The Environmental Health officer has made the following comments with regard to condition 16:

In relation to the above application, I have now reviewed the following documents:

- Soils Ltd. Phase I Desk study (ref.: 17028/DS, dated November 2016)
- Soils Ltd. Compiled Ground Investigation Report (ref.: 17403/CGIR, dated February 2019)
- Soils Ltd. Soil Gas Risk Assessment (ref.: 17403/SGRA, dated April 2019)

SOIL GAS PRESENT : YES

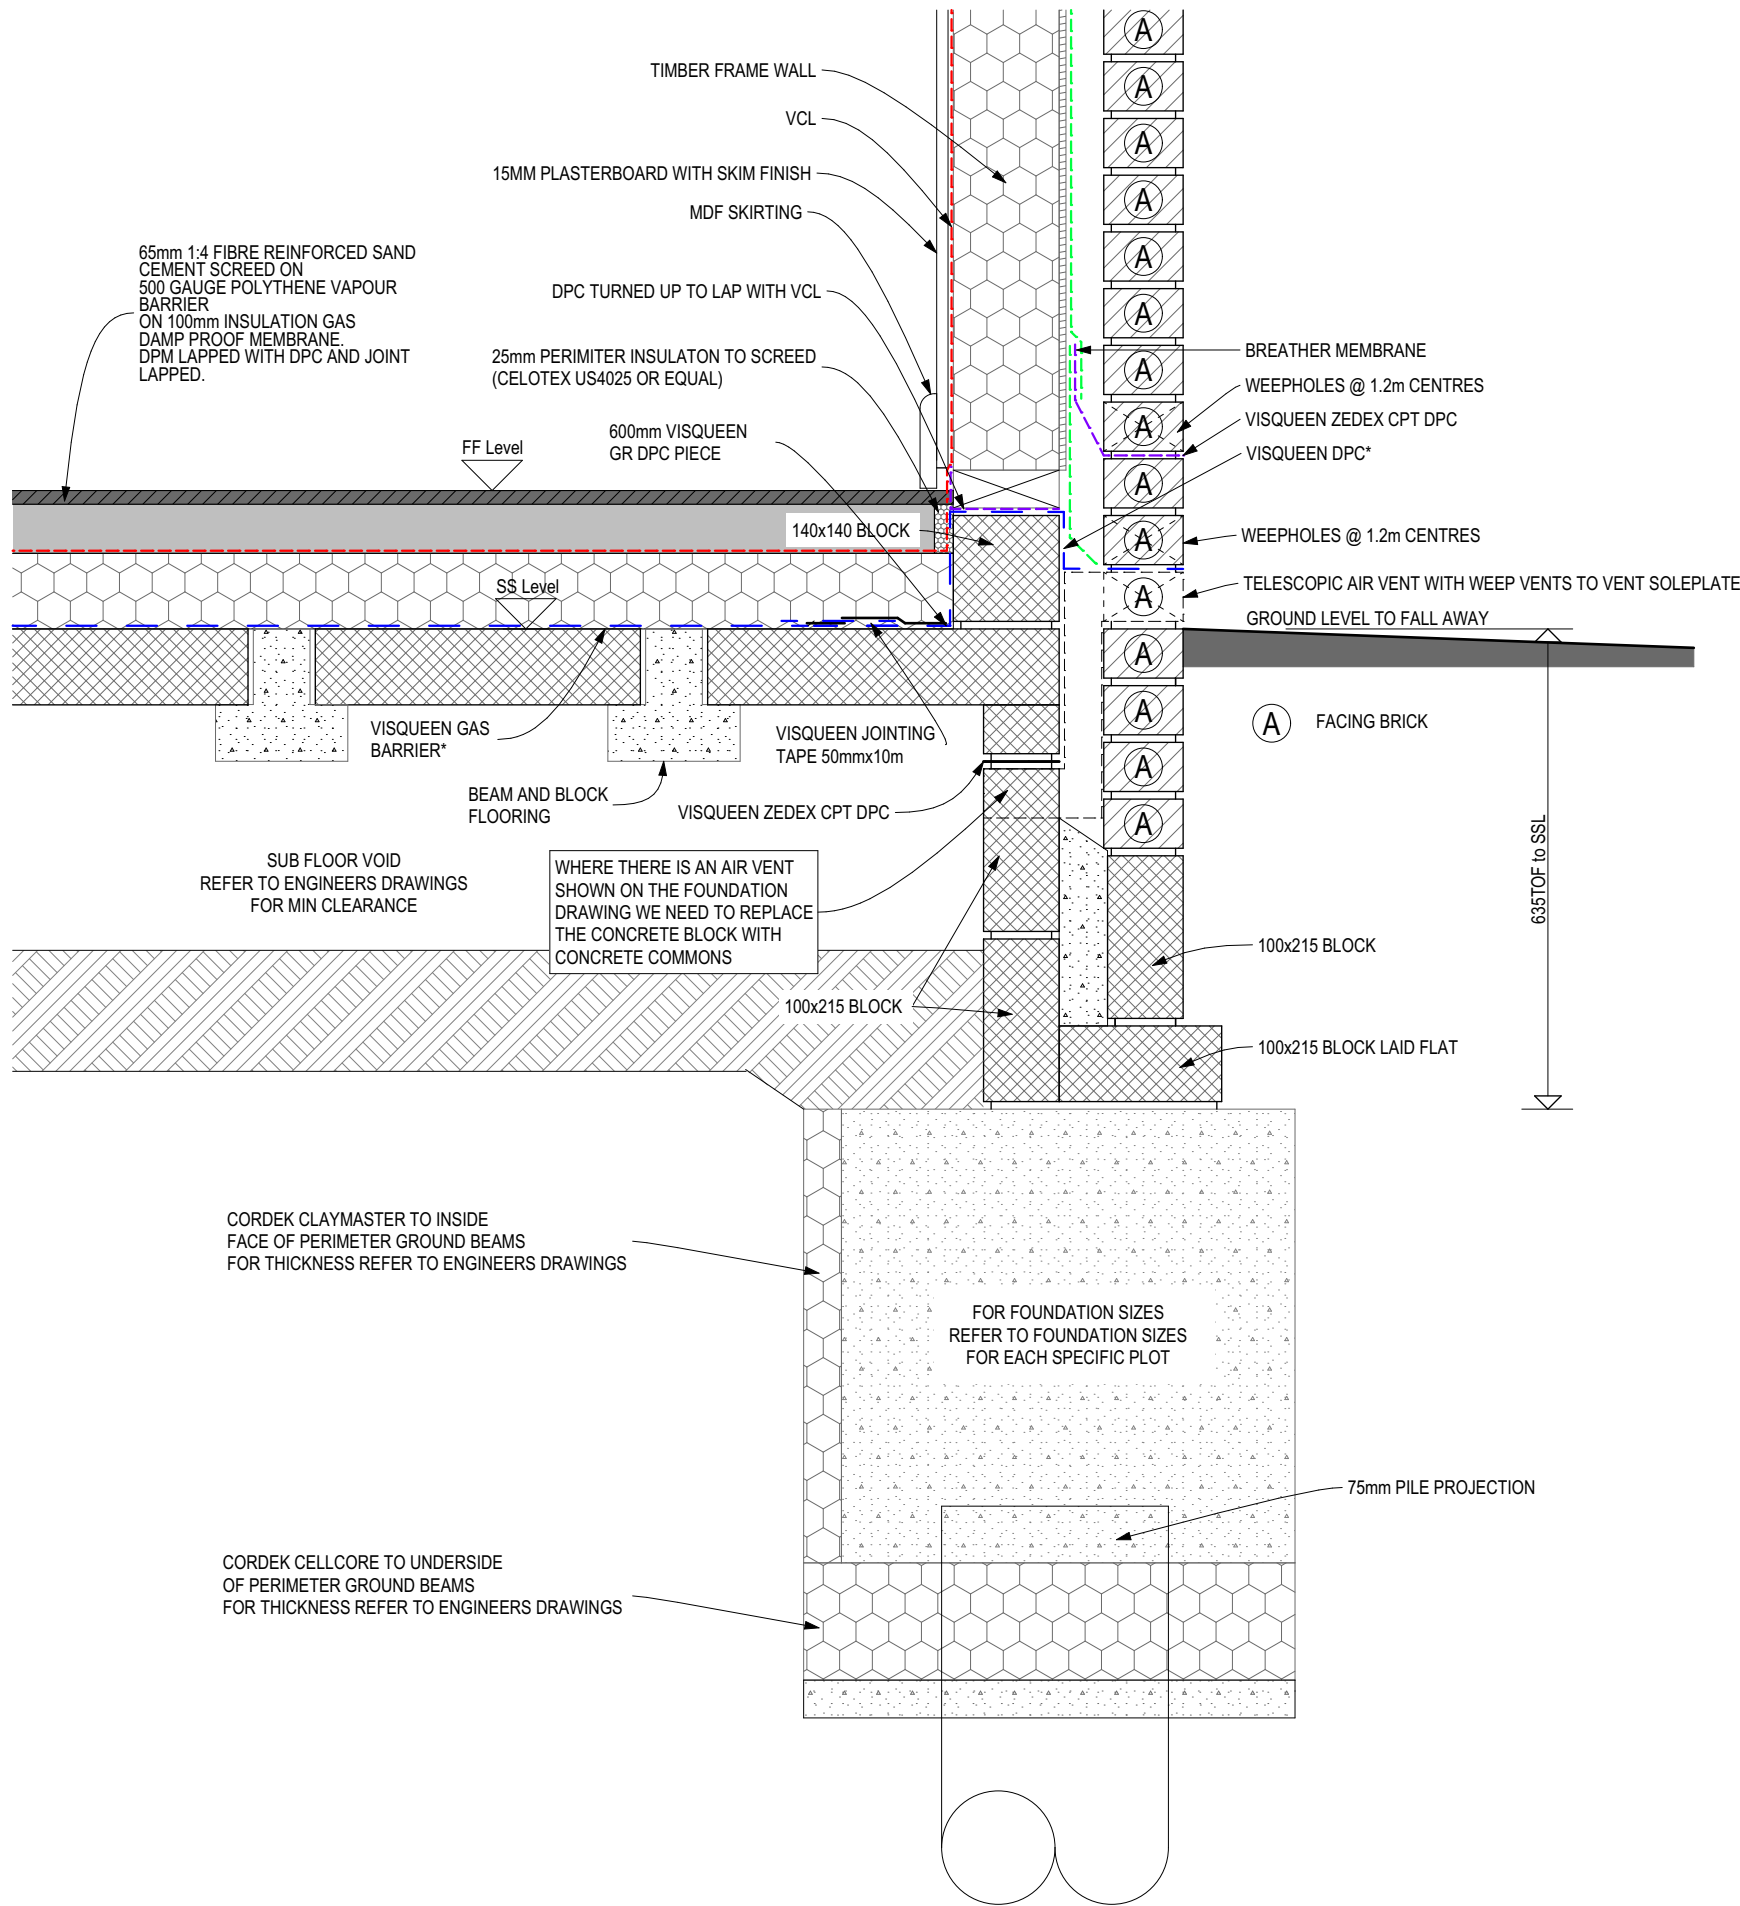
- the CGIR identified an exceedance of lead at 0.10 metres depth and stated that based on the proposed development plan, no remediation was required, however no management of this exceedance is mentioned and no subsequent sampling of the garden areas was undertaken;
- the SGRA concludes that gas protection measures are likely to be required, however no detail is provided.
